**Re: Juan Tabo Hills Unit 3B Open Space Grading and Drainage Plan  
Engineer's Stamp dated 9-20-12 (M22/DD017)**

Re: **Juan Tabo Hills Unit 3A/3B Open Space Grading and Drainage Plan**  
**Engineer's Stamp dated 8-22-12 (M22/D017)**

RE: JTH G & D Plan for Units 3A, 3B and 1-C-1, 1-C-2 Sheets 1-3

CITY OF ALBUQUERQUE PUBLIC WORKS DEPARTMENT	
JUAN TABO HILLS UNIT 3B OPEN SPACE GRADING & DRAINAGE PLAN	
DESIGN REVIEW COMMITTEE	CITY ENGINEER APPROVAL
CITY PROJECT NO. 756187	ZONE MAP NO. M-21-Z/M-22-Z
SHEET 3 OF 4

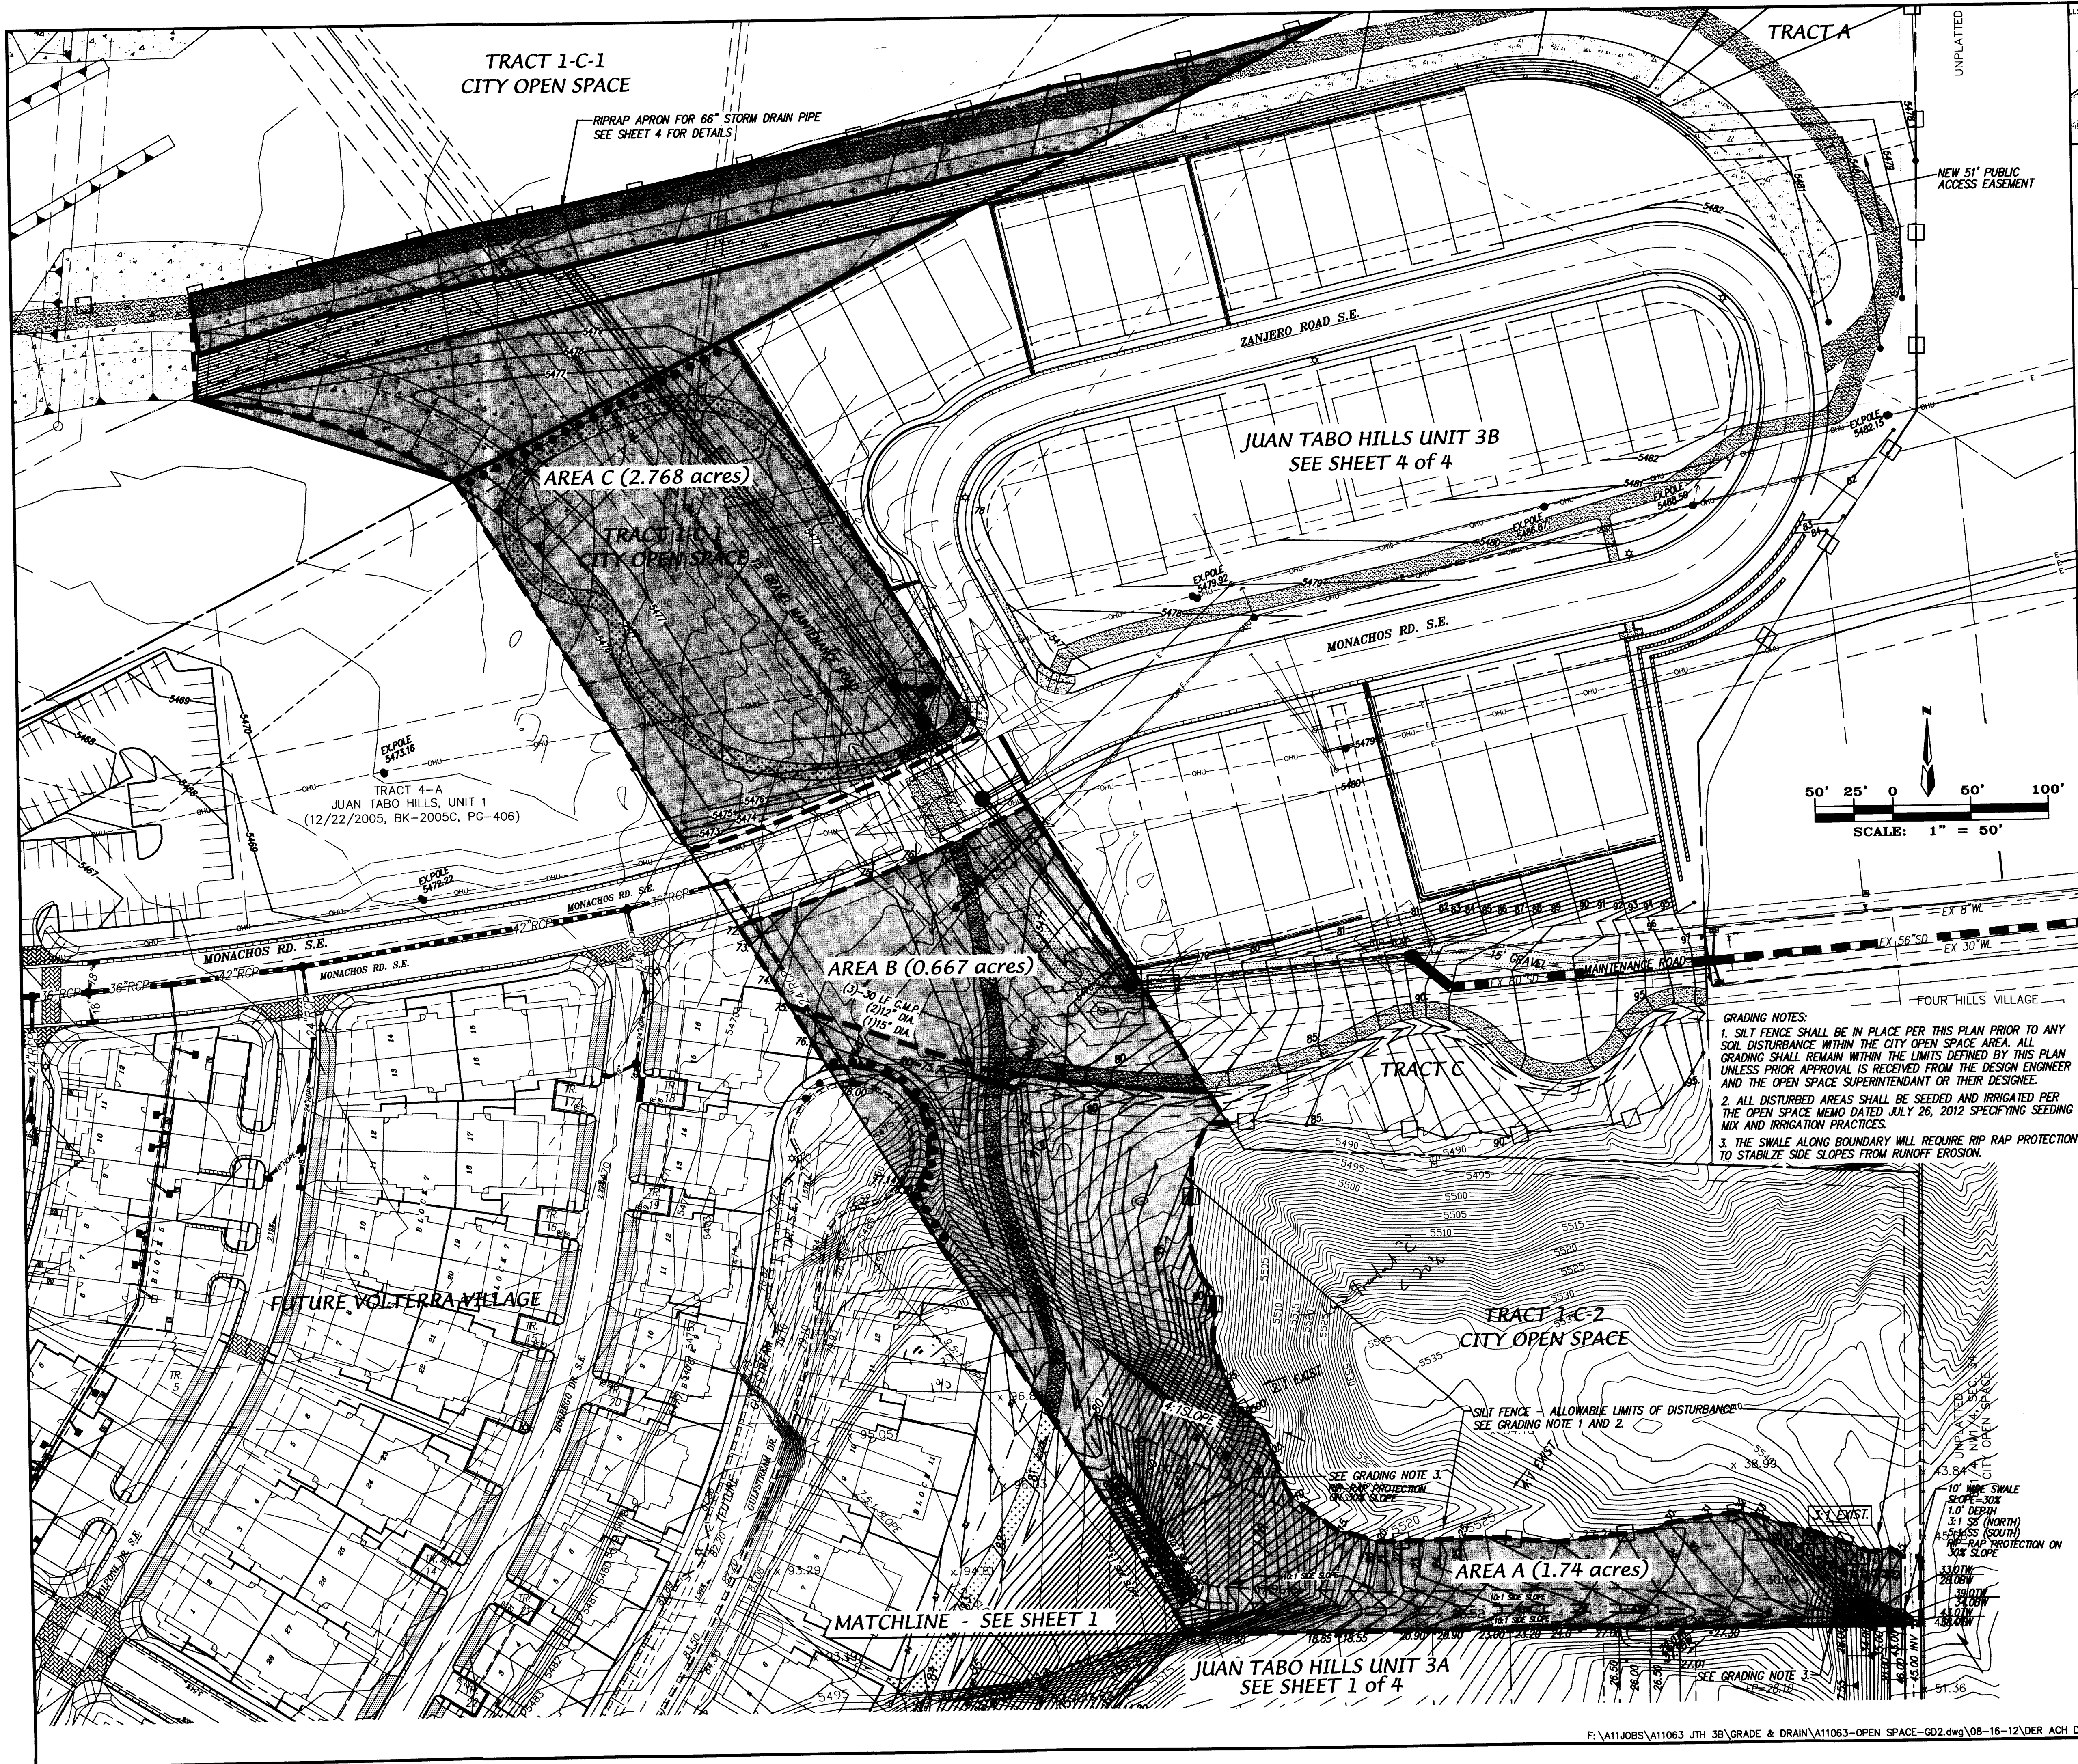
- Since this area is not detailed in the drainage report for Juan Tabo Hills Unit 3A, 3B or Volterra Village, most DPM requirements for a grading and drainage plan are applicable. Some are discussed below.
  - Provide a flow for the culvert under the trail, with supporting calculations.
  - Provide inverts and a size for the culvert.
  - Show/discuss the current flood plain.
  - A Floodplain Development Permit, through this office, will be required for any grading or construction in a floodplain.
  - If you prefer, the drainage report for Juan Tabo Hills Unit 3A could be updated to include this area.
- NM 87103

1. OK,
2. Supplemental information attached with open space sub basin boundary, ahymo printout and flow calculations for the culvert under the trail in open space,
3. Invert and size of pipes in provided on the revised plan,
4. Discussion on the current floodplain can be found in Juan Tabo Hills Unit 3B (M22/D016B) file. A FEMA exhibit is included with this letter for information.
5. OK, a Floodplain Development permit will be submitted prior to final plat for JTH Unit 3A,
6. OK.

TITLE: JUAN TABO HILLS UNIT - 3A
GRADING & DRAINAGE PLAN

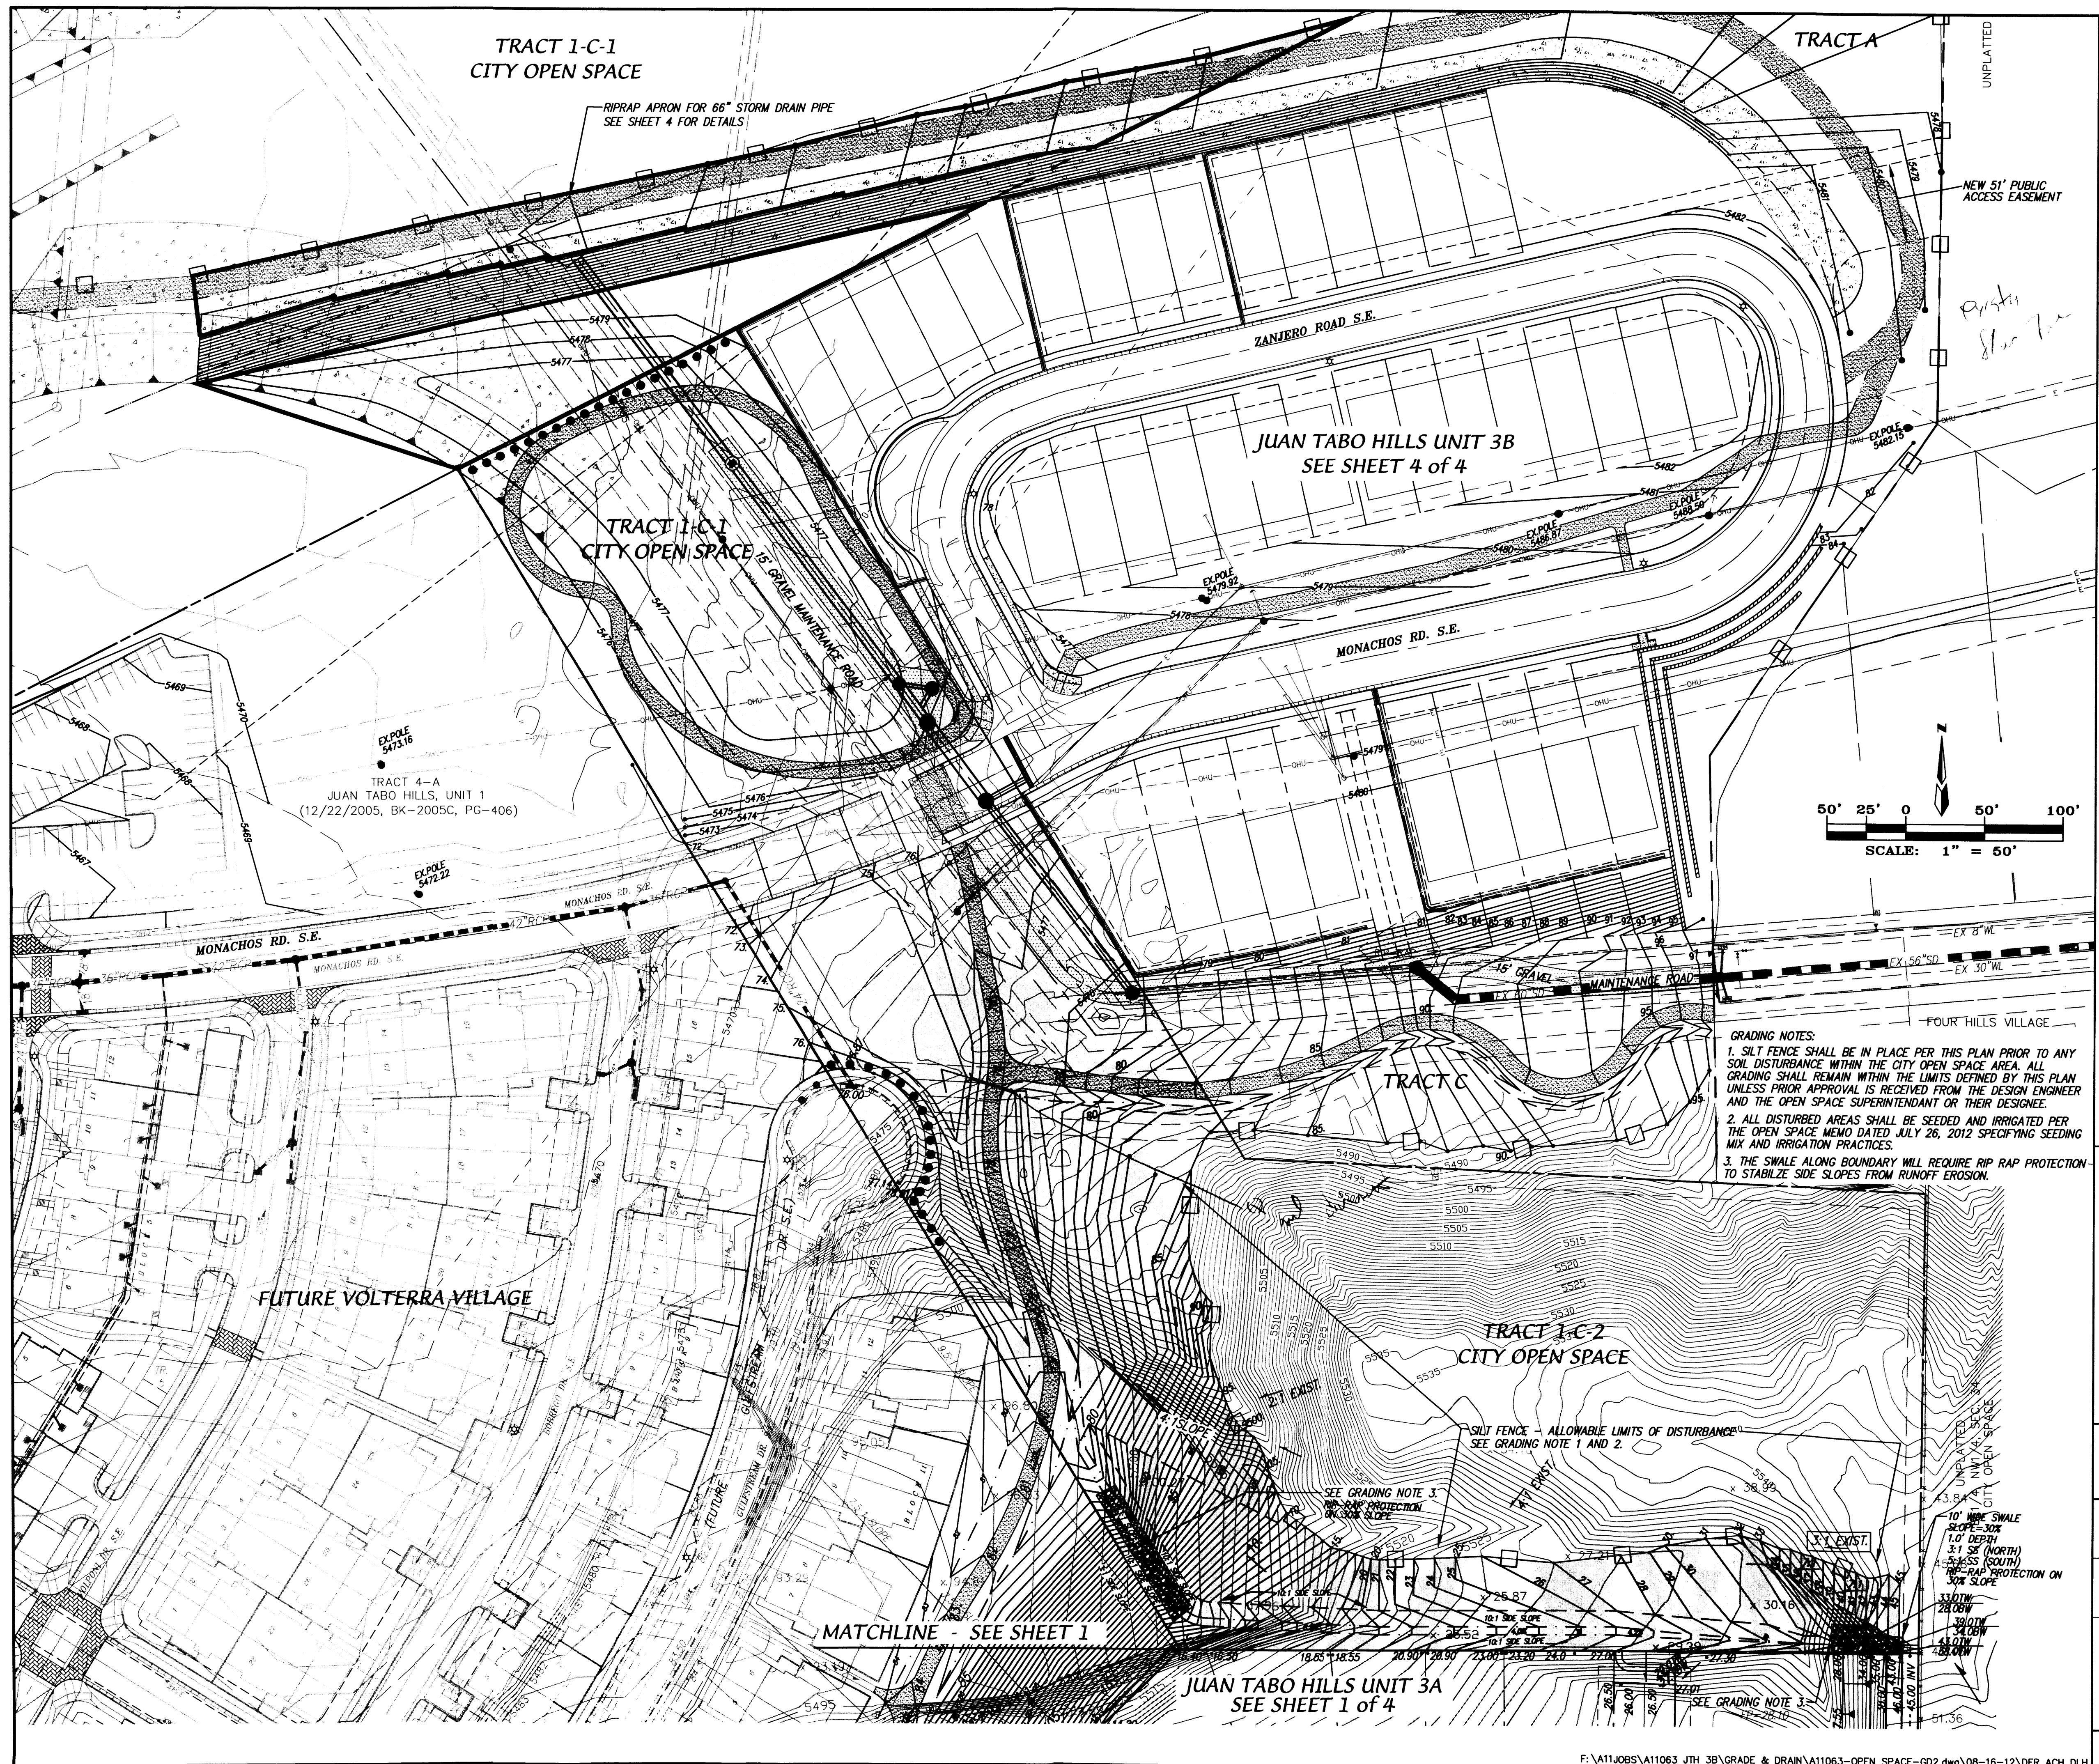
1. Please include Silt Fence in Legend.
2. PRD-OS defers to Hydrology regarding tie in grades at north boundary of 3A where it meets the south boundary of Tract 1-C-2 Open Space. There is some question as to the elevations of the proposed tie -ins.

TITLE: JUAN TABO HILLS UNIT 3B
OPEN SPACE GRADING & DRAINAGE PLAN

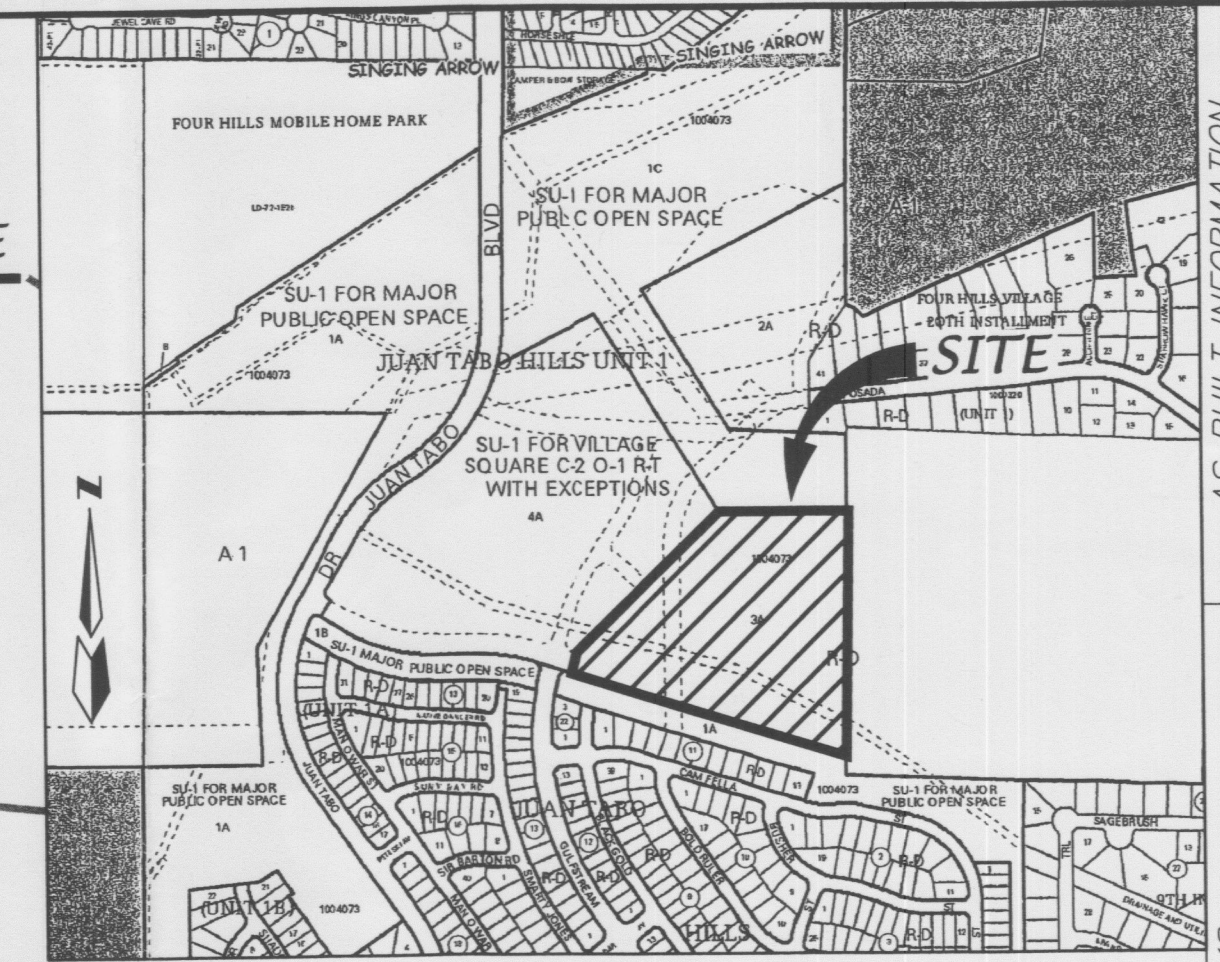
1. Open space would prefer a broader swale in the middle of the Open Space Tract 1-C-2 rather than the swale shown along the southern boundary of the tract. During our field visit we suggested a tie slope to meet existing grade at the bottom of the current flat . WE DEFER TO HYDROLOGY REGARDING GRADE CHANGE ISSUES AT THIS BOUNDARY BETWEEN THE OPEN SPACE AND UNIT 3A.

2. At the west edge of the existing Open Space knoll, the silt fence delineating the undisturbed land is shown left of the knoll leaving a previously disturbed cut area not regraded at the agreed upon 3:1 slope. PRD-OSD defers to Hydrology as to the manner in which the grades can be adjusted south of the disturbed area to reduce the steepness south of the cut area and at the same time fill the cut to a 3:1 slope to match the existing undisturbed hill. Hydrology has suggested that you can tie the proposed 90 contour to the existing 90 contour near the north side of the Open Space Tract so the proposed contours are similar to the existing contours of the hill.

3. South of the "Tract C" label and south of the trail location is a swale that is shown crossing the east -west trail and then crossing the trail again north of the east-west trail intersection with the north-south trail. Earlier drawings proposed a valley gutter south of the intersection of the two trails near the Gulfstream cul de sac. If at all possible the swale should be directed to the valley gutter to direct the flows to the west side of the north-south trail which results in water crossing the trail at one location - the valley gutter.

4. Please adjust the construction road on Tract A to join the trail proposed crossing of Monachos Road to connect rather than offset these two "paths".
5. Please add Silt Fence and Very Very Large Boulders to the Legend.

6. Please add Large boulders to edge of Gulfstream Drive outside limits of R.O.W. to discourage vehicle entry to the Open Space. The exact minimum size can be determined and agreed to at DRC .

7. Please delete wording as follows from Note 1 of the Grading Notes on this Sheet as follows:  
Silt Fence shall be in place per this Plan prior to any soil disturbance within the City Open Space area.
